OXFORDSHIRE COUNTY COUNCIL'S RESPONSE TO CONSULTATION ON THE FOLLOWING DEVELOPMENT PROPOSAL

Application no: 23/00517/F

Proposal: Redevelopment of the site to include the demolition of existing buildings and development of new accommodation across 5 buildings for employment uses (Class E(g)(ii) and (iii)) plus ancillary amenity building, outdoor amenity space, car parking, cycle parking, landscaping and associated works

Location: New Science Park Land West Of The Junction With The Boulevard, Oxford Airport, Langford Lane, Kidlington

**Figure 2 Cycling Concept for Langford Lane following OCC Kidlington LCWIP**

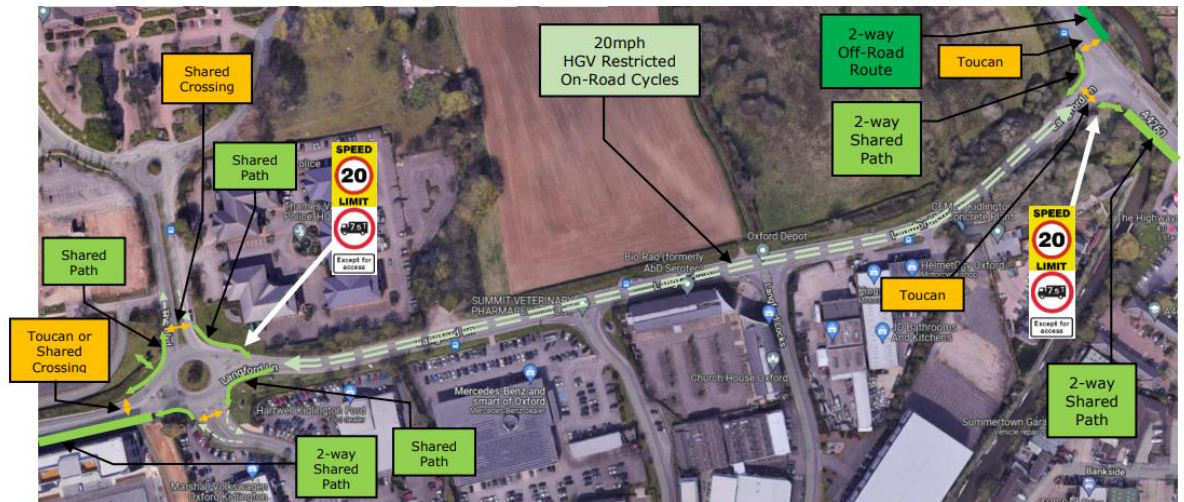
Figure 3 in the TA usefully illustrates possible cycle improvements for Langford Lane (part reproduced below). The measures at The Boulevard roundabout which are feasible and have not yet been implemented are considered necessary for this proposal and are therefore required as part of the S278 works.

The 2-way Shared Path is in place to the west of the roundabout, so an improved connection to this facility from the site is required. This will be a formal crossing, i.e. a Toucan or parallel crossing, at a suitable location to be determined and verified by Road Safety Audit. Similarly, an appropriate crossing of The Boulevard is necessary for cyclists from the site to be able to bypass the roundabout and for pedestrians to cross to the bus stop. Footways around the four corners of the junction should be widened for shared use and tie-in with the crossing points, as well as providing a clear transition between on- and off-road cycling as highlighted in the LCWIP.

- A formal (Toucan or parallel) crossing on the western Langford Lane arm of the roundabout junction with The Boulevard
- An informal crossing of The Boulevard, just north of the roundabout junction with Langford Lane
- Widening of the footways to 3m around the Langford Lane / The Boulevard roundabout and conversion to shared use, including improved cycling transitions on and off the carriageway
